DECISION DELEGATED TO HEAD OF PLANNING

Application No: H16-0005-24 **Applicant:** Harrison Springfield Property

Proposal: Details of archaeological investigation, foul water disposal & external boxes for gas and electrical supplies (Conditions 3, 11 & 14 of H16-1131-21)

Location: 38 Spring Gardens Spalding Lincolnshire

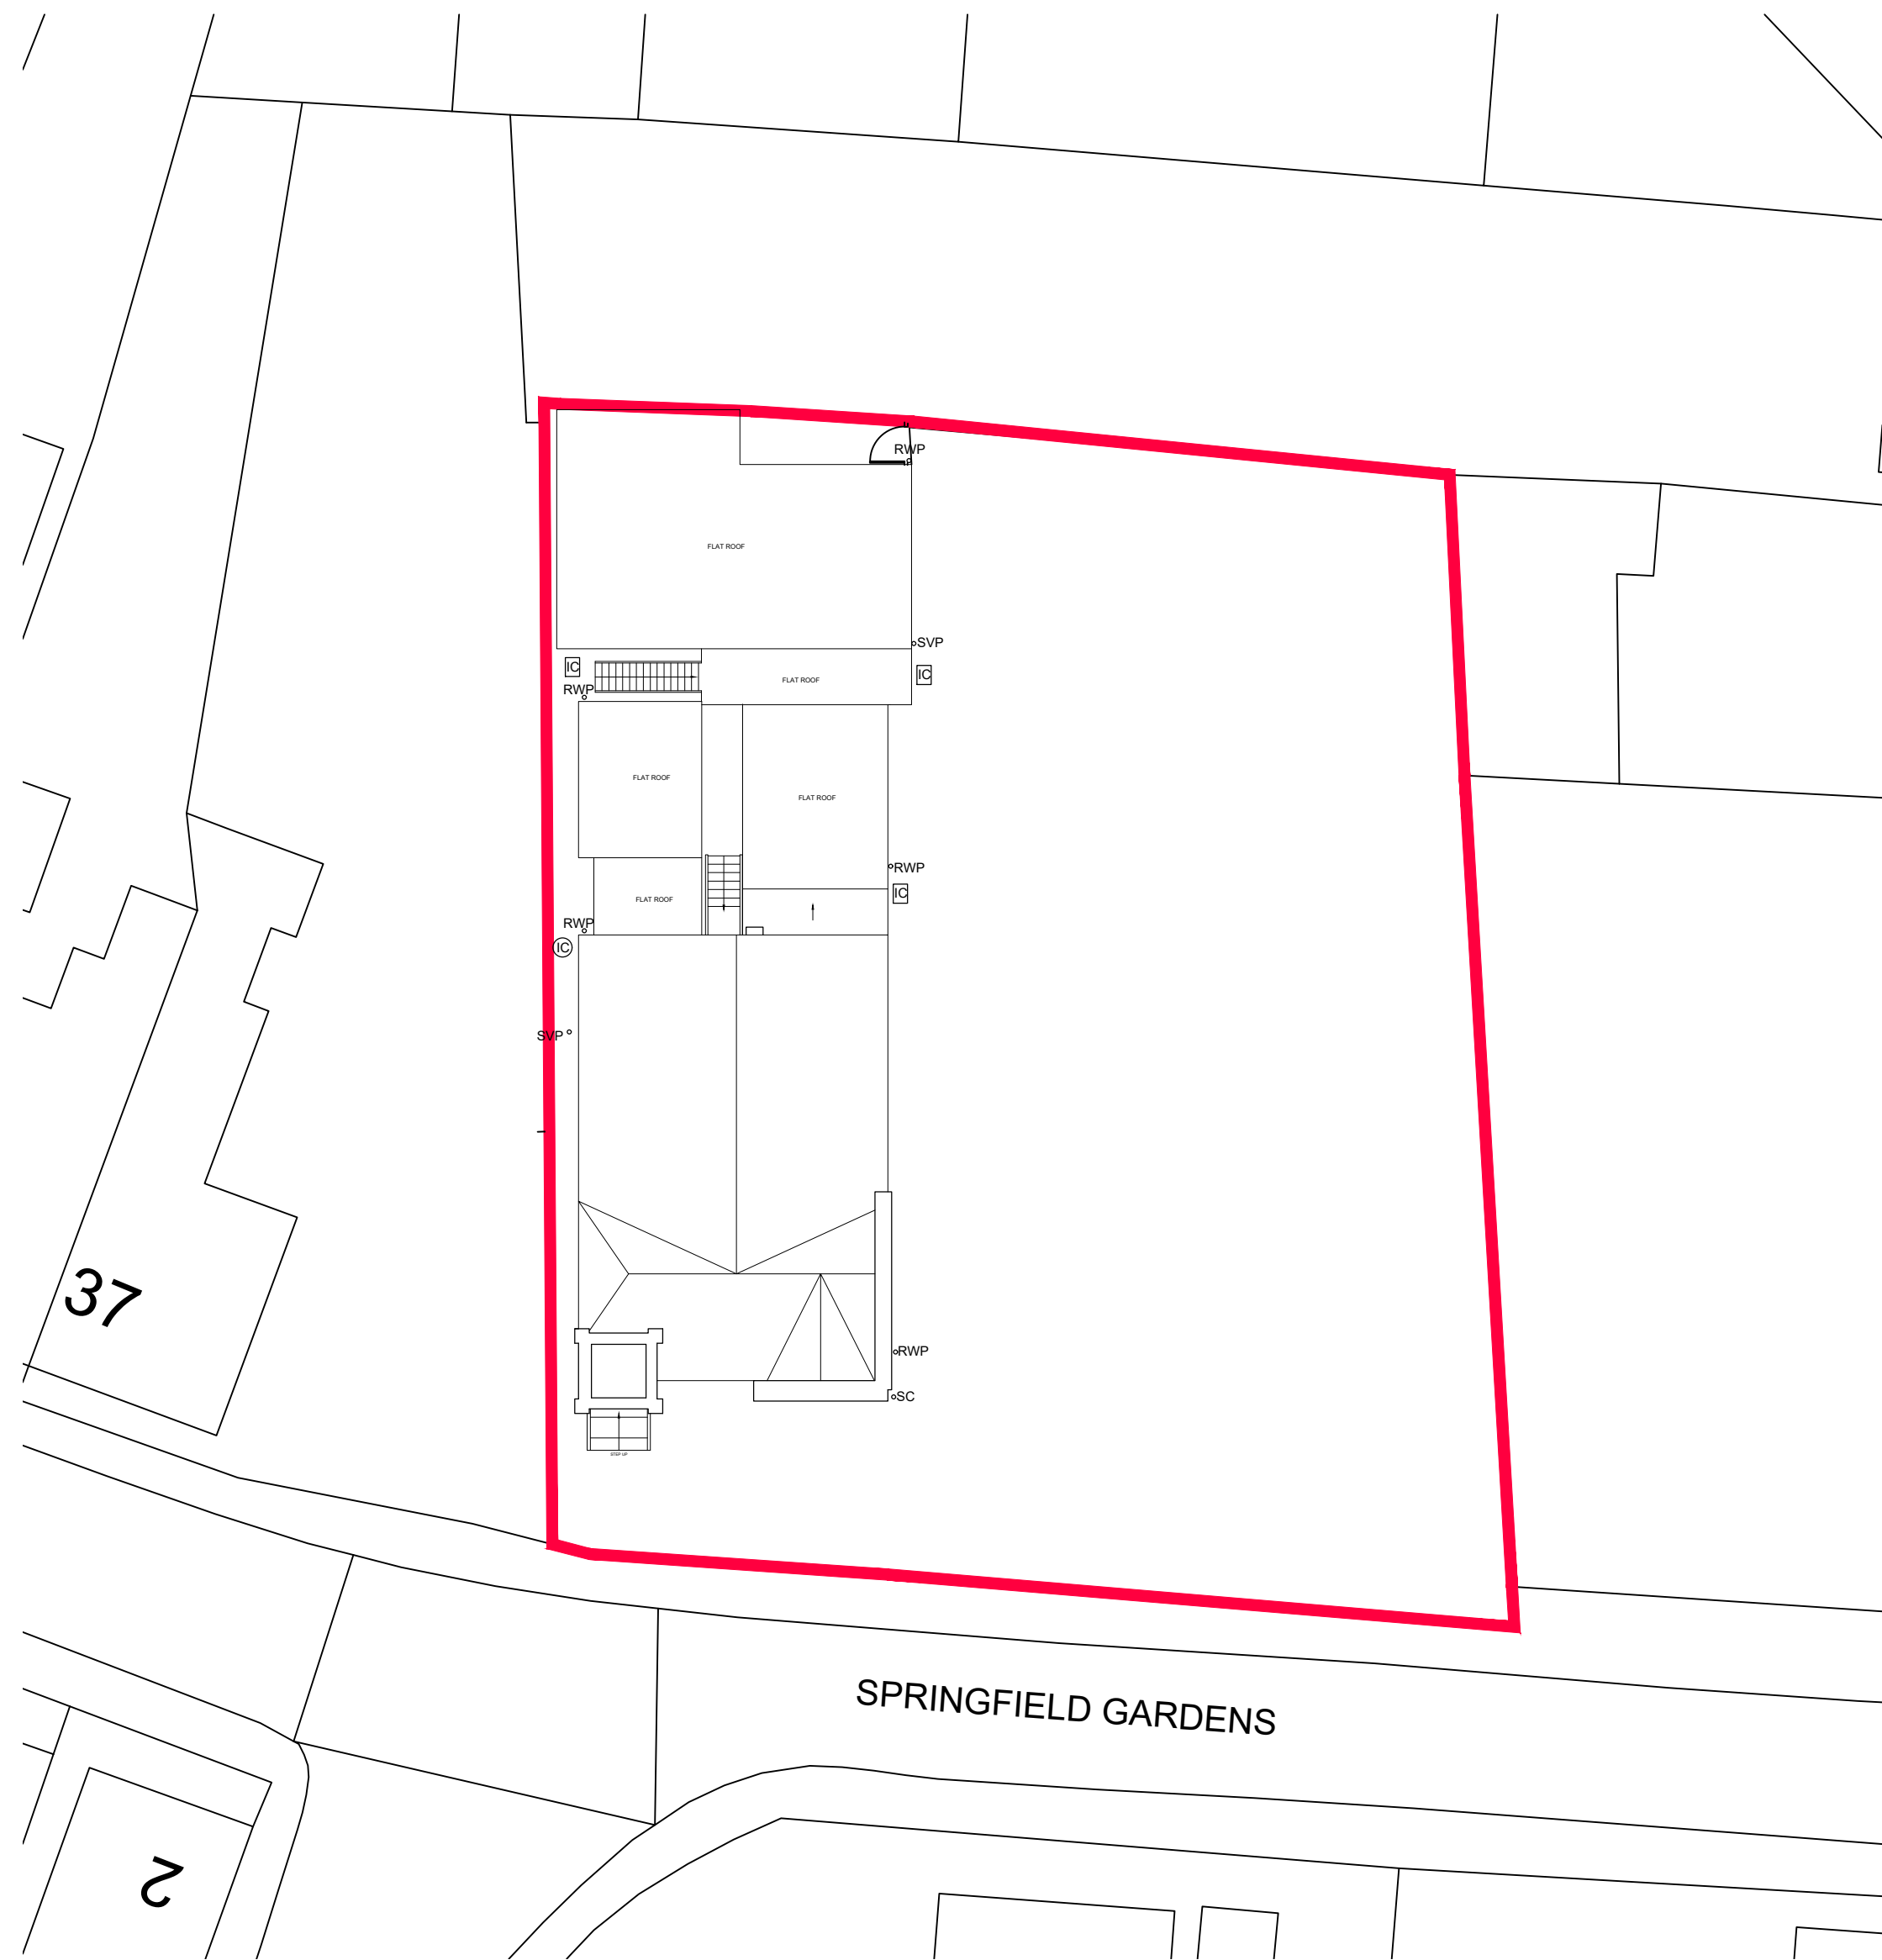
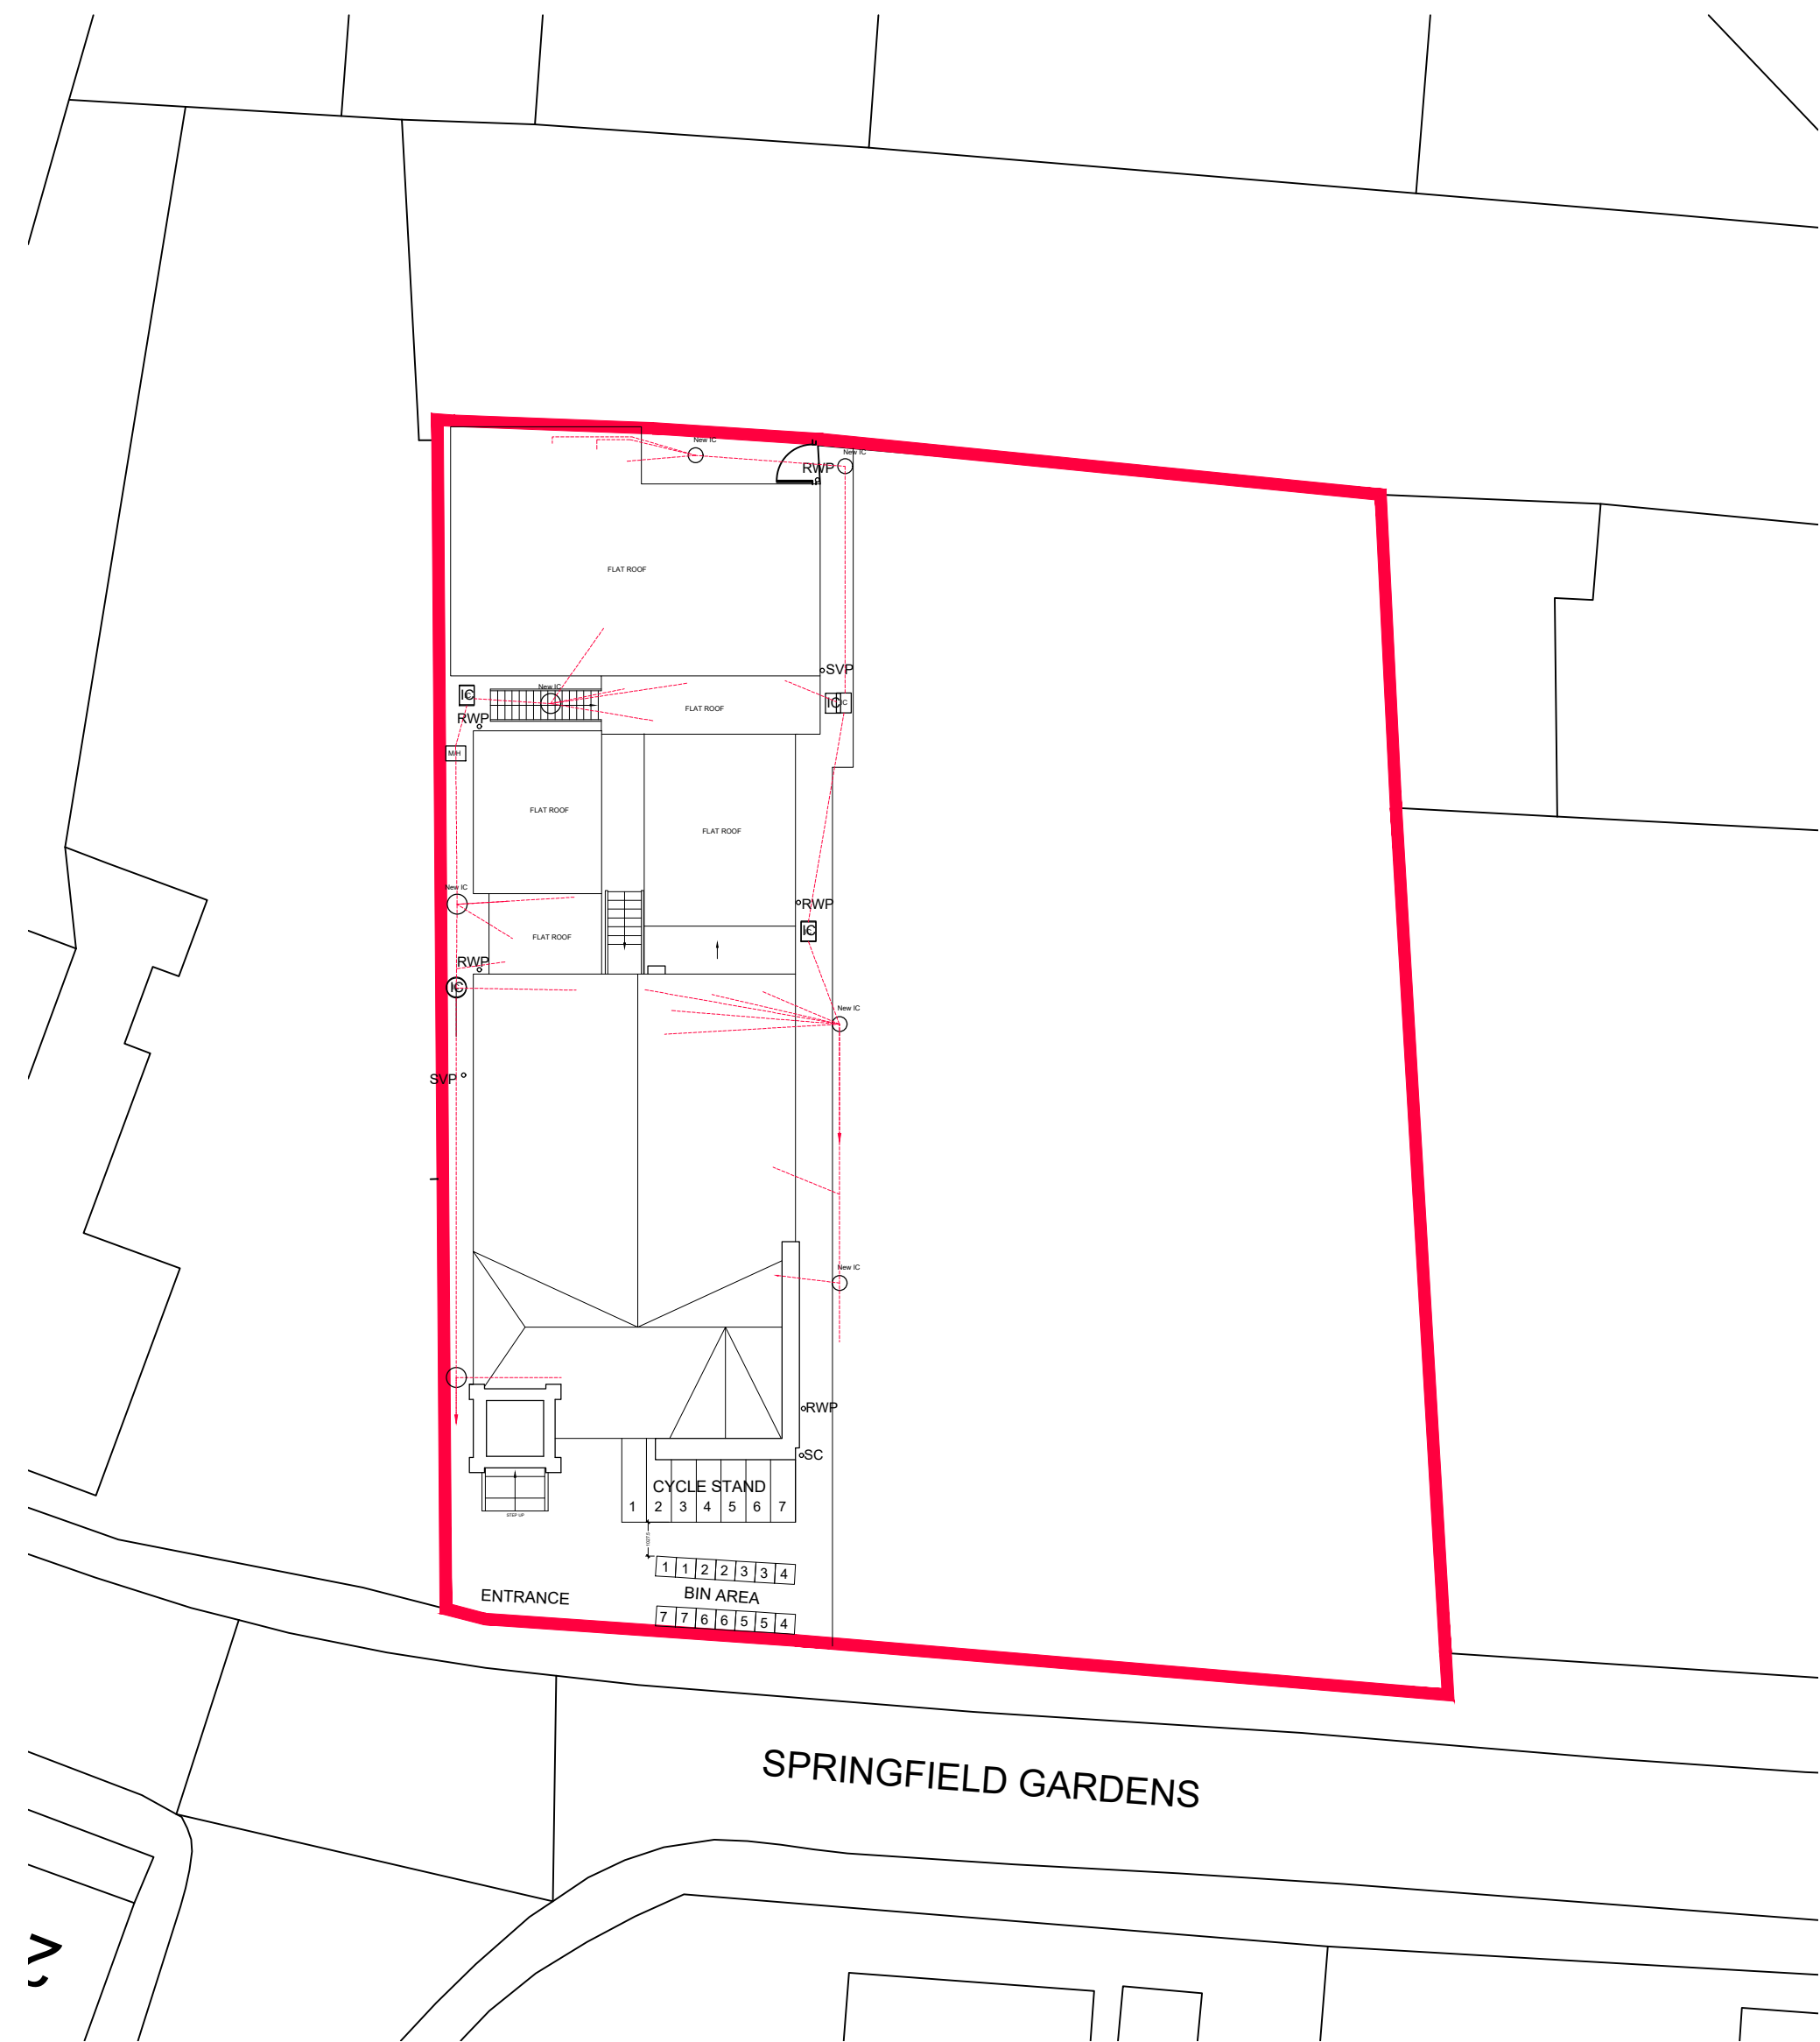
The applicant has shown bin storage number PP/23/0758 - 03 and has confirmed that they intend to use the local planning authority's refuse collection for disposal of waste. The proposed block plans shows that an area allocated for bin storage that is located to the front close to Springfield Gardens. The reason for the conditions was:

The siting of loose bins in this location would detract from the building, which is of high merit. Therefore, the location of these bins is disappointing as it would detract from the merit of the building. Furthermore the conditional approval was based upon the private refuse collection, the applicant has stated that the local authority intend to be utilised. This is contrary to the condition.

On this basis the condition remains undischarged.

Ground Floor Plan
Scale 1:50

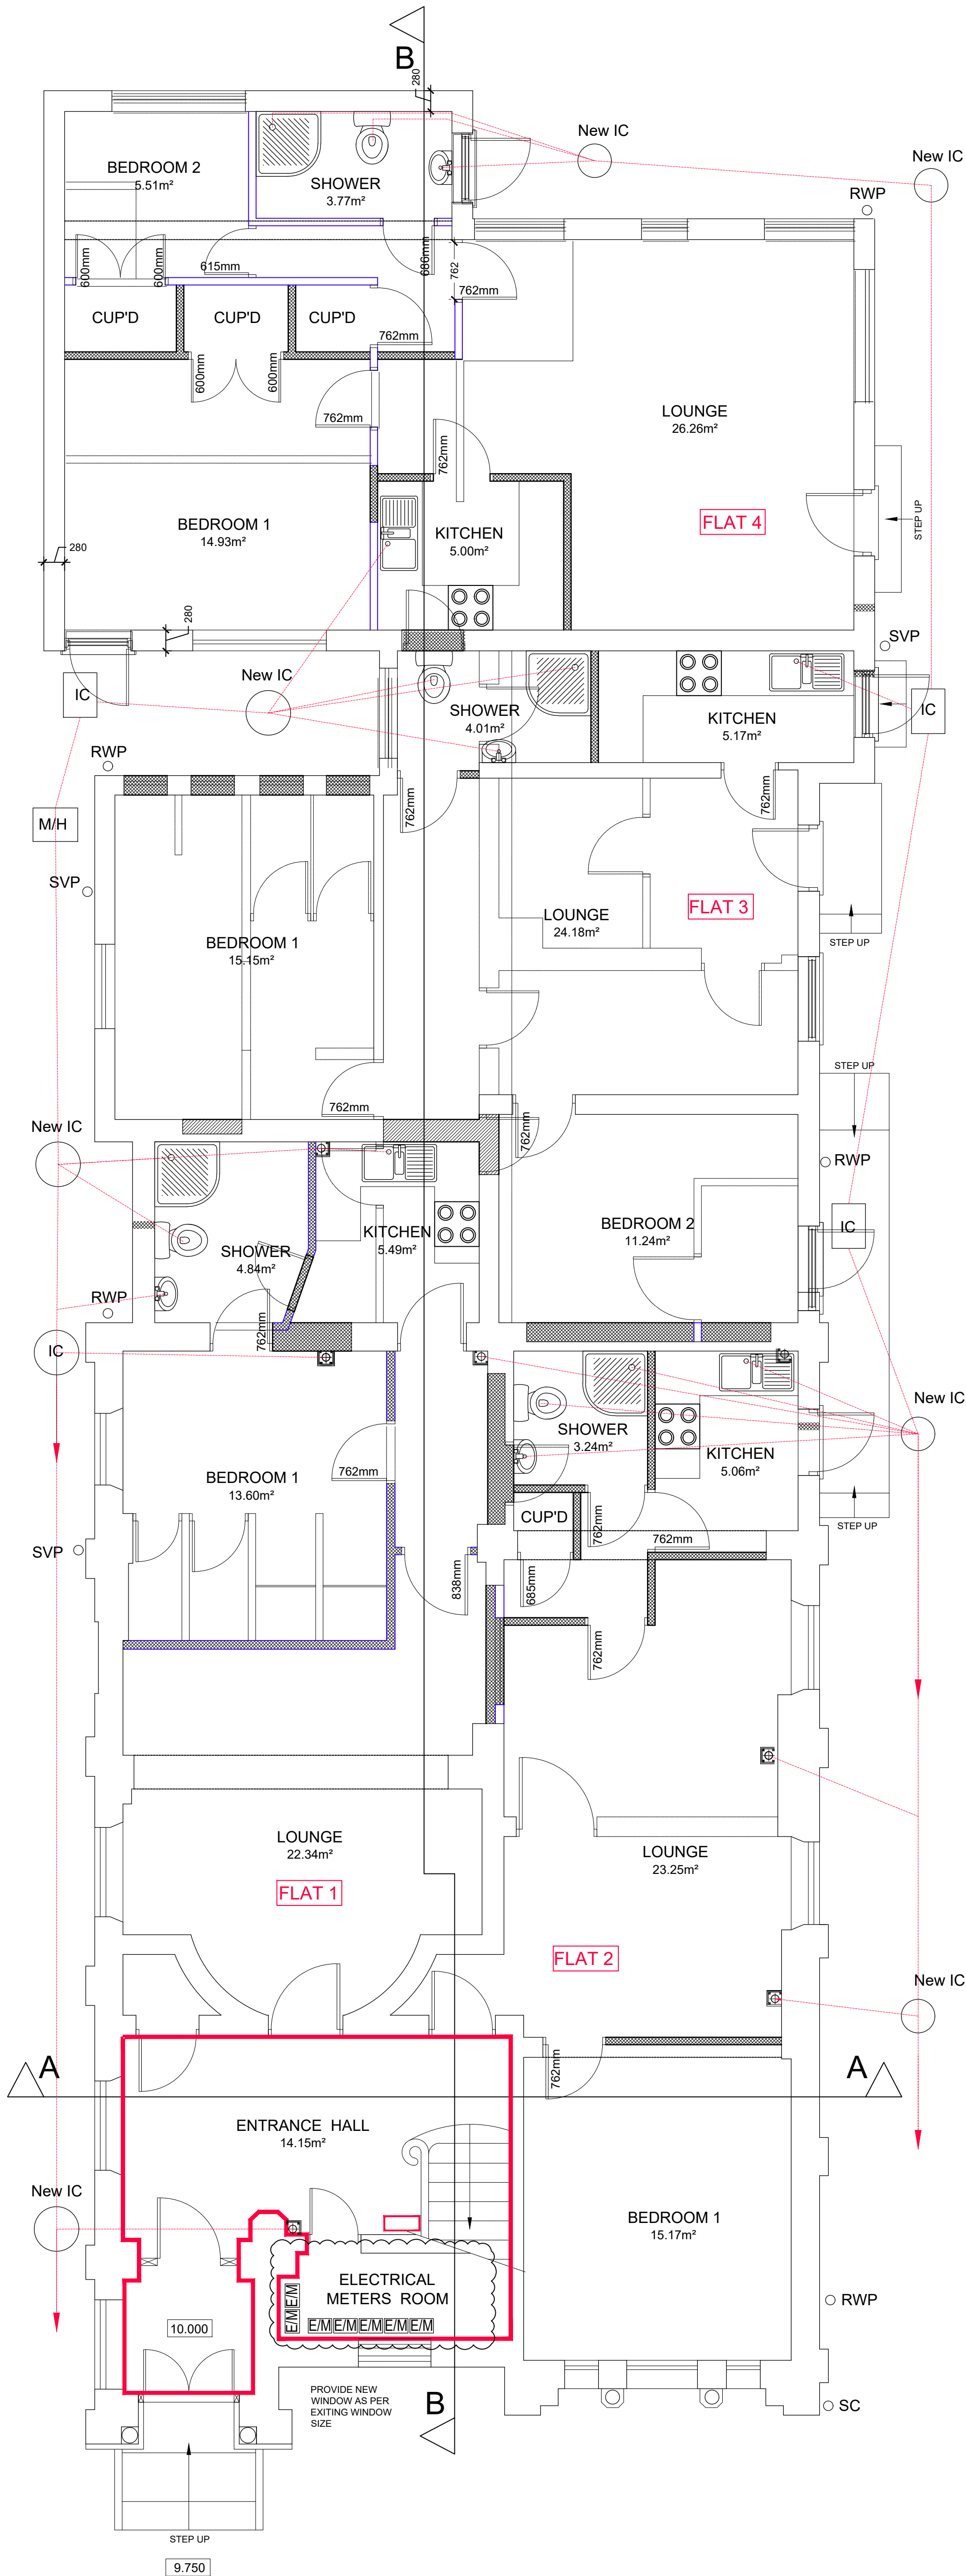
The proposed ground floor plan shows that an internal electrical metres room will be provided. Vent Pipes are also shown in appropriate locations. Given this approach limited impact would be had upon the external appearance of the building in relation to these topics.
